Subject: Sears Plat SUB23-001; Mercer Island, WA
Resubmittal #5

Thank you for reviewing the Preliminary Short Subdivision and SEPA Review applications permit documents. We at Navix Engineering have prepared a response below to the recent decision from the hearing examiner decision on tree retention and hope you find the resolution of the review comments acceptable. Please feel free to contact me with any questions or coordination items you have.

TREE RETENTION NOTES

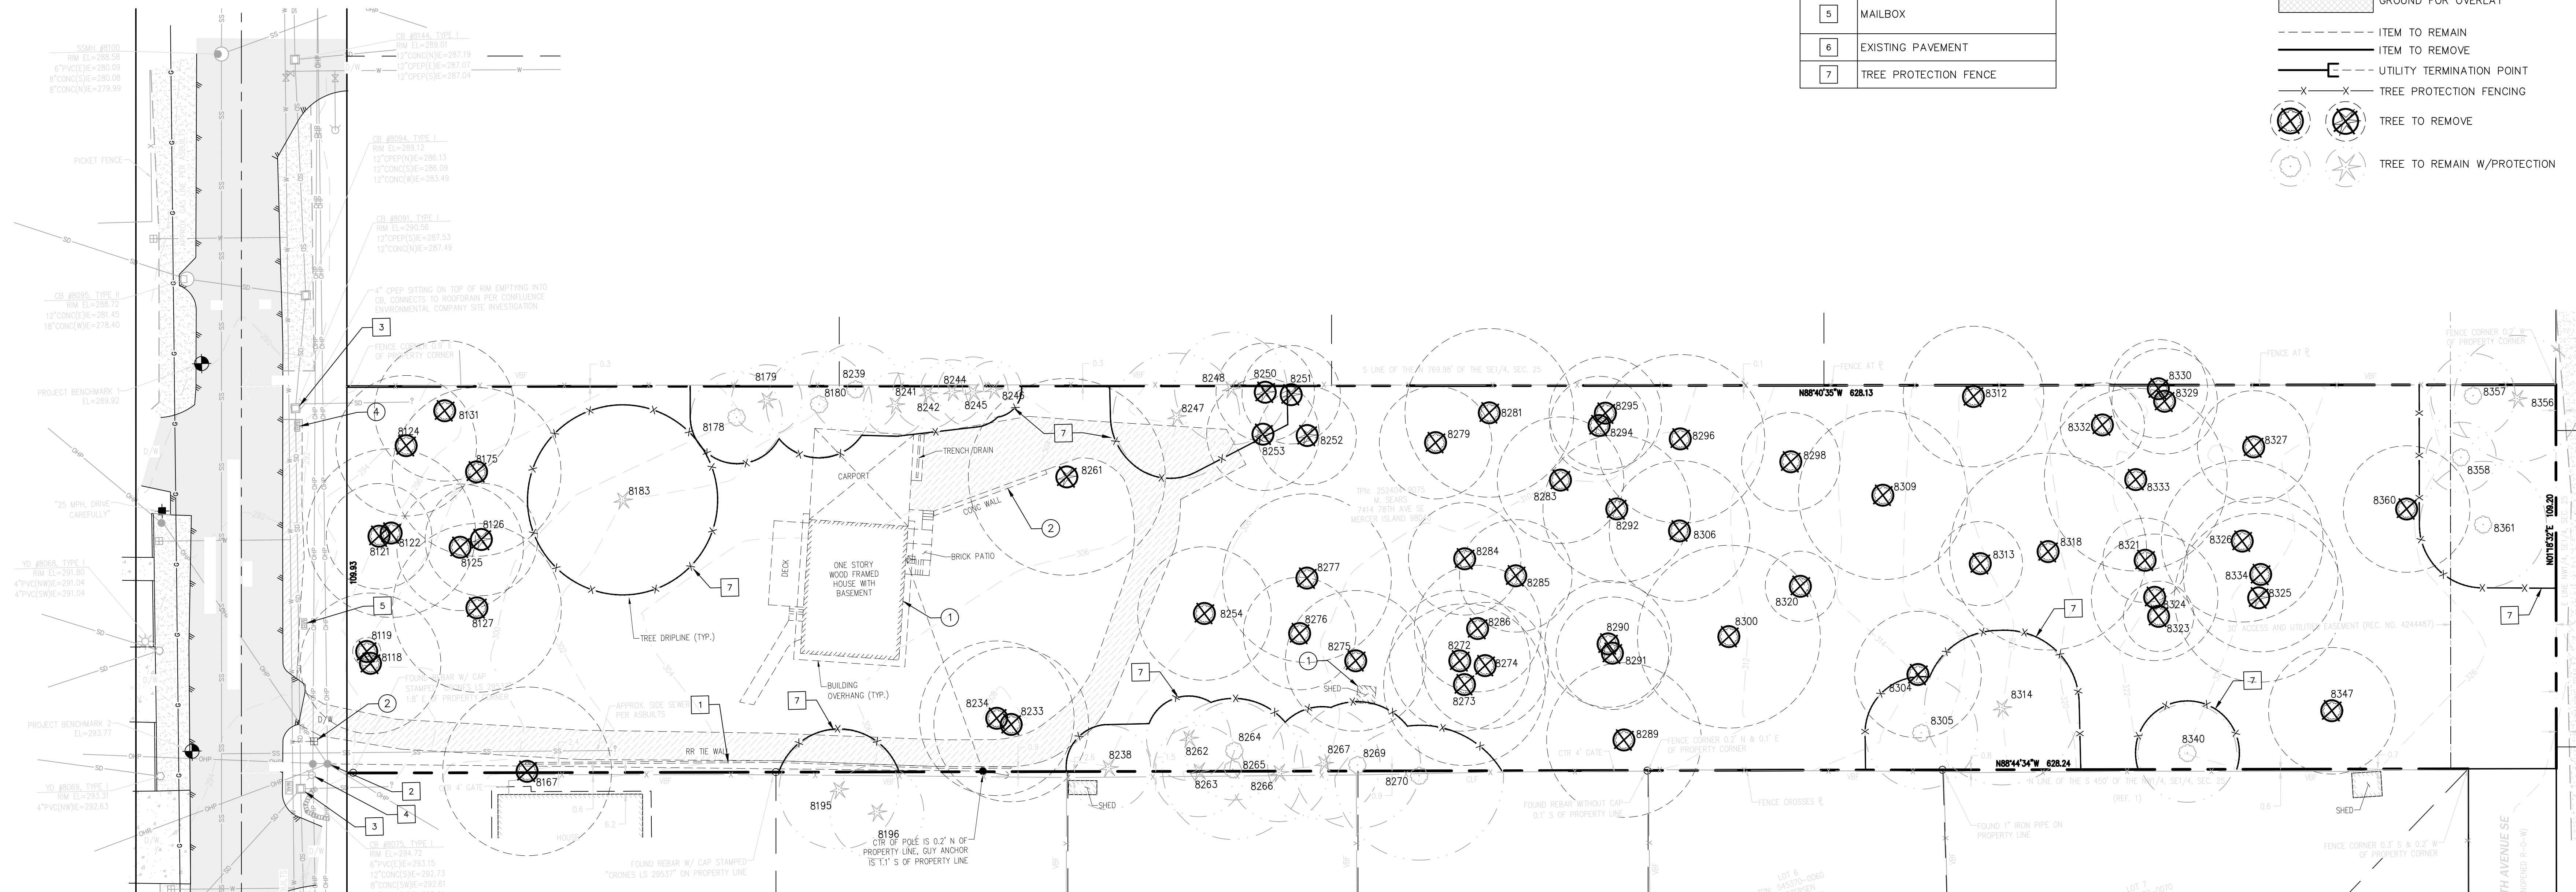
1. The calculation for saving 30% of the tree canopy must include the total of viable and nonviable trees.

Response: The additional trees that have been noted as retained are as follows:

- 8178, 8179, 8180, 8264, 8265, 8267, 8305
